**KIRKLEES METROPOLITAN COUNCIL
INVESTMENT & REGENERATION SERVICE**

DELEGATED DECISION TO DETERMINE PLANNING APPLICATIONS

Reference No:	2024/62/92548/W
Site Address:	40, Bradford Road, Fartown, Huddersfield, HD1 6JE
Description:	Change of use of dwelling to 7 bed House of Multiple occupation including erection of 3 storey extension and associated alterations'
Recommending Officer:	Lucy Taylor

Officer Report.

PROPOSED BASEMENT FLOOR
SCALE 1:100 AT A3

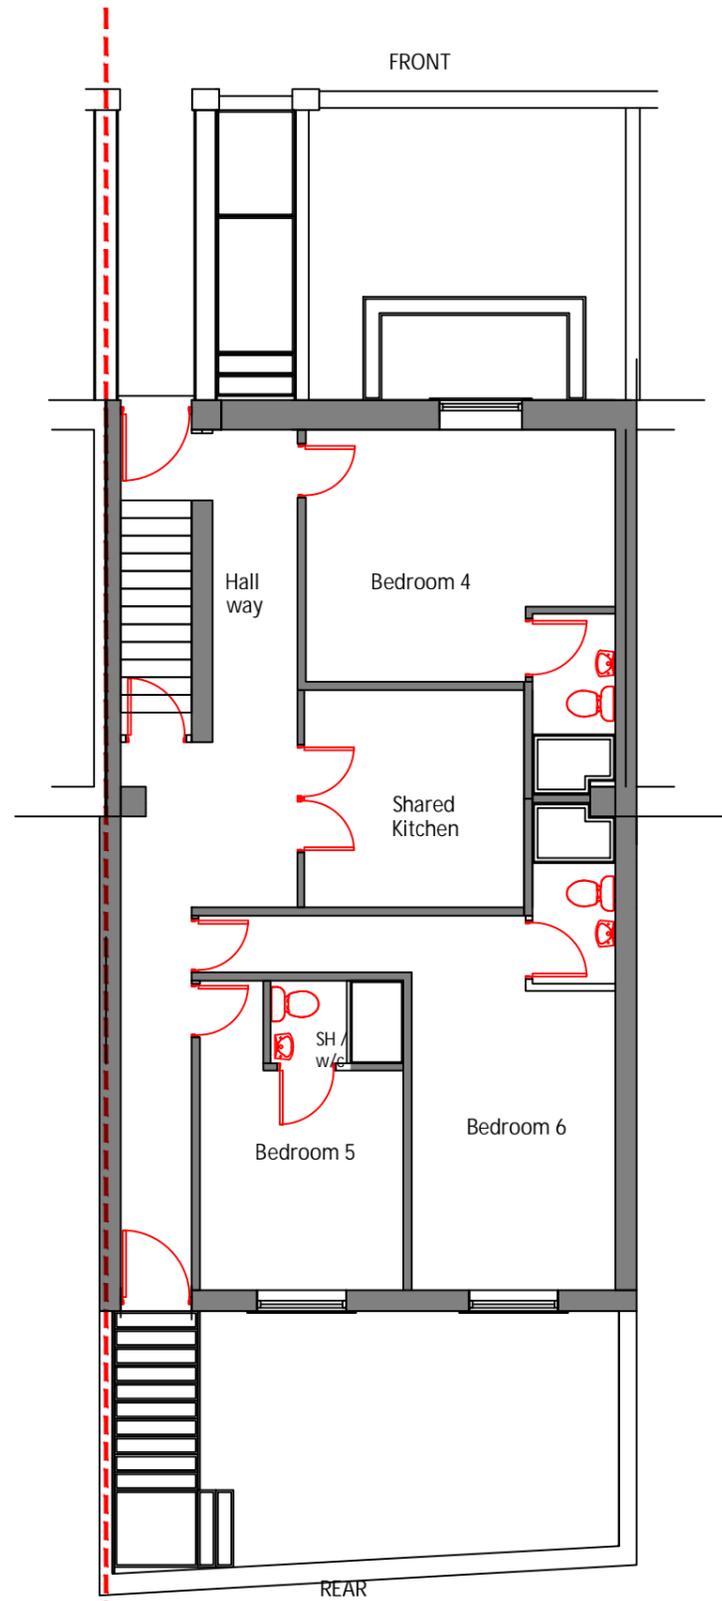
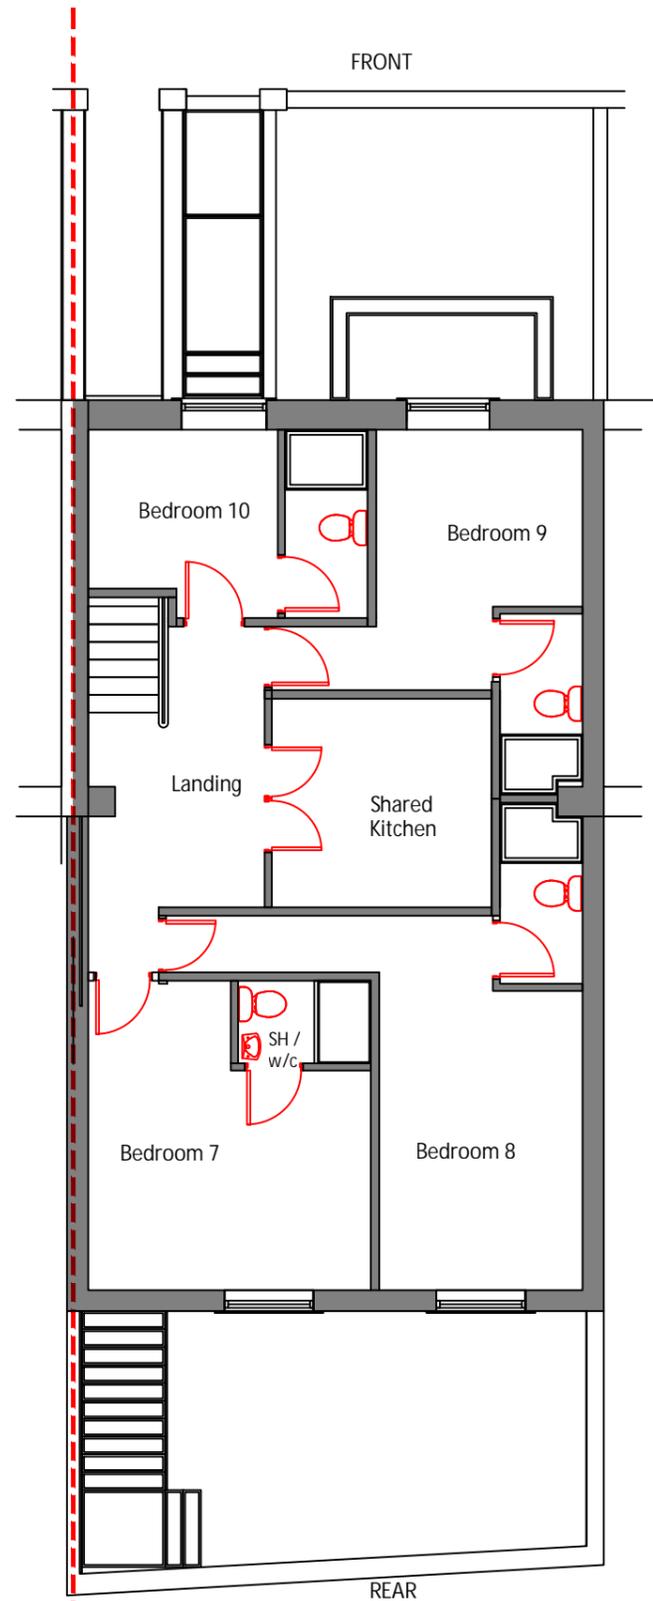
The proposed basement floor would host a shared kitchen and dining area and 2 store rooms.

The proposed ground floor would host 3 en-suite bedrooms and a shared kitchen.

The proposed first floor would host 4 en-suite bedrooms and a shared kitchen.

Officers have calculated the proposed bedrooms to have the following (approximate) internal floor areas:

- bedroom 1 – 16.4m²
- bedroom 2 – 12.5m²
- bedroom 3 – 19m²
- bedroom 4 – 10.1m²
- bedroom 5 – 19.3m²
- bedroom 6 – 13.8m²
- bedroom 7 – 17.5m²

3. The proposed development would present poor standards of amenity for future occupiers, by reason of the size of bedrooms two and four. Therefore, the development would be contrary to Policy LP24(b) of the Kirklees Local Plan, guidance as set out within the Housebuilders Design Guide SPD and Chapter 12 of the National Planning Policy Framework.

Proposed block plans
Scale: 1/500

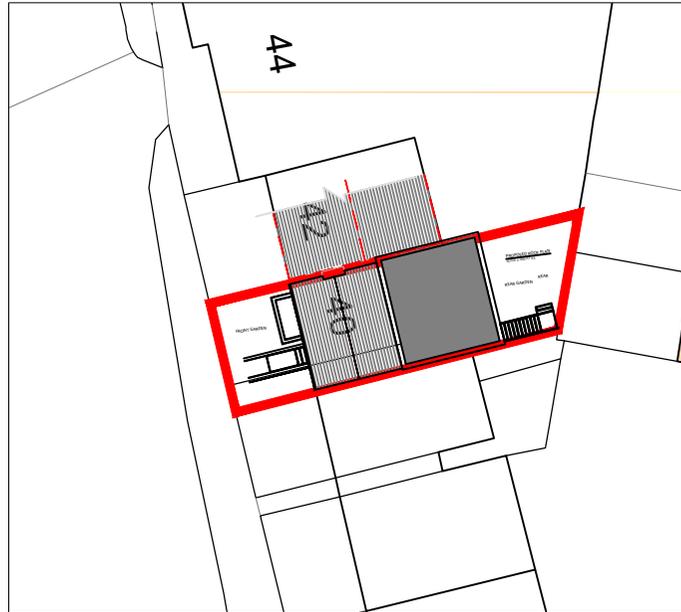
The proposed 3 storey extension is not considered to be of a size / scale that would be viewed as proportionate to the host dwellinghouse, resulting in the loss of the majority of the amenity space which currently exists to the rear of the site. The 3-storey extension is also considered to have a depth and width which would fail to be viewed as subservient to the host dwelling and would fail to be separated from either shared boundary to both sides. The three-storey extension is considered to result in a loss of character to the form of the existing terrace property, significantly projecting beyond the adjoining rear elevations of No.'s 38 and 42 Bradford Road.

The proposed three storey extension would be erected up to the shared boundaries with both No.'s 38 and 42 Bradford Road and would exceed the rear elevations of these neighbouring properties. Both No. 38 and No. 40 Bradford Road are registered on the Council's GIS mapping system as residential dwellings.

The three-storey extension would exceed the rear elevation of No. 38 Bradford Road by approximately 2.3 metres and would breach a line of 45-degrees with regard to the windows on the rear elevation of No. 38.

The three-storey extension would exceed the rear elevation of No. 42 Bradford Road by approximately 2.5 metres and would breach a line of 45-degrees with regard to the windows on the rear elevation of this neighbouring property.

The three-storey extension would be separated from the rear boundary of the site by a minimum distance of approximately 4.5 metres and would be separated from the adjacent residential dwellings of No. 17a Calton Street by approximately 11.6 metres and No. 19 Calton Street by approximately 13.3 metres. The amenity space serving No.'s 17a and 19 Calton Street is located between the rear boundary of No. 40 Bradford Road and the siting of the neighbouring properties.

PROPOSED REAR ELEVATION
SCALE 1:100 AT A3.

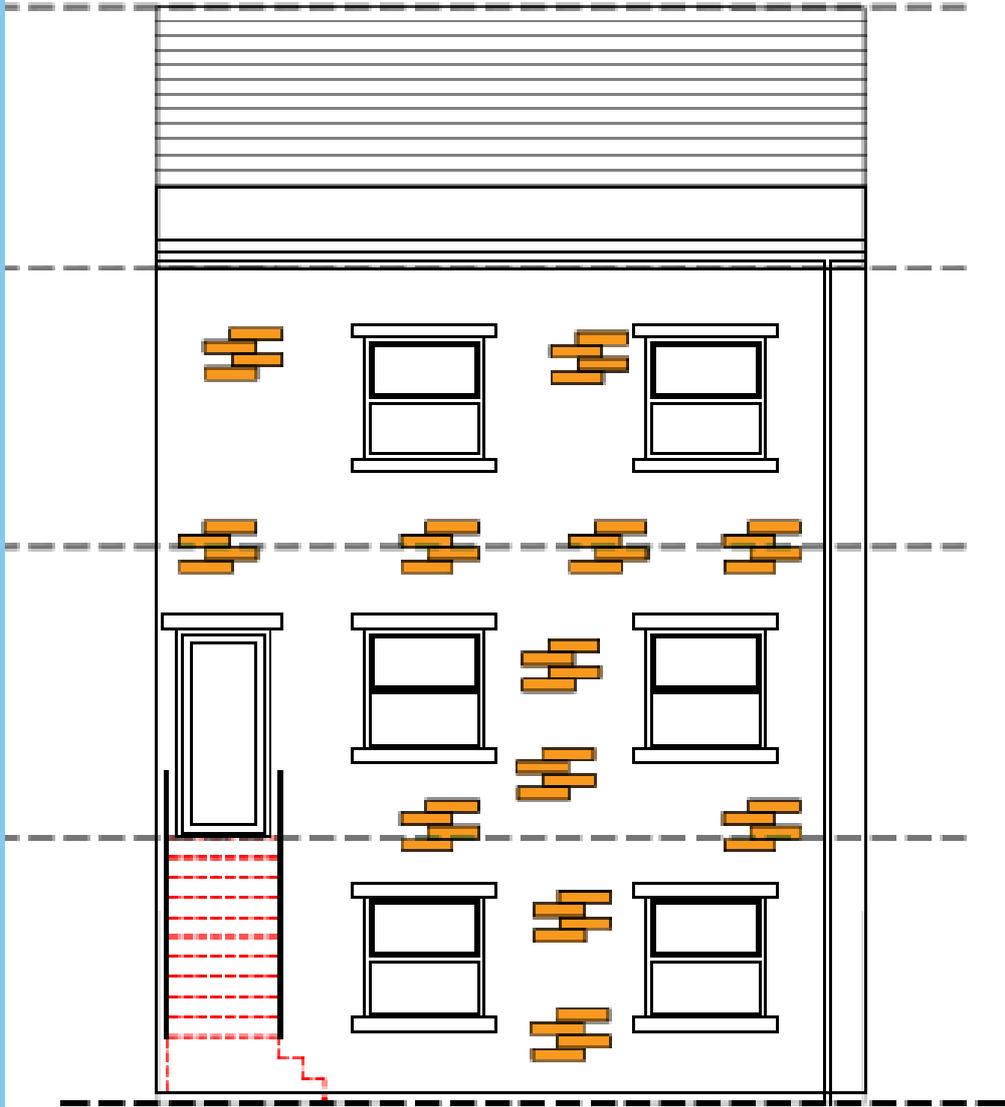
The proposed three storey extension to No. 40 Bradford Road is proposed to host habitable room windows to the ground and first floor, specially four windows all serving bedrooms. At present, there are only 2 habitable room windows to the rear elevation of No. 40 Bradford Road, one at basement floor level and one at ground floor level, which have a greater separation distance from both the rear boundary and dwellings of No.'s 17a and 19 Calton Street.

Given the separation distances as set out above and the intensification of the site, resulting in a significant increase in habitable room windows to the rear elevation, it is concluded that the three storey extension would have an unacceptable impact on residential amenity, having a harmful impact upon the living conditions associated with No.'s 38 and 42 Bradford Road, as well as No.'s 17a and 19 Calton Street. The scheme therefore fails to comply with Policy LP24 of the Kirklees Local Plan, guidance as contained within the Housebuilders Design Guide SPD and Chapter 12 of the NPPF.
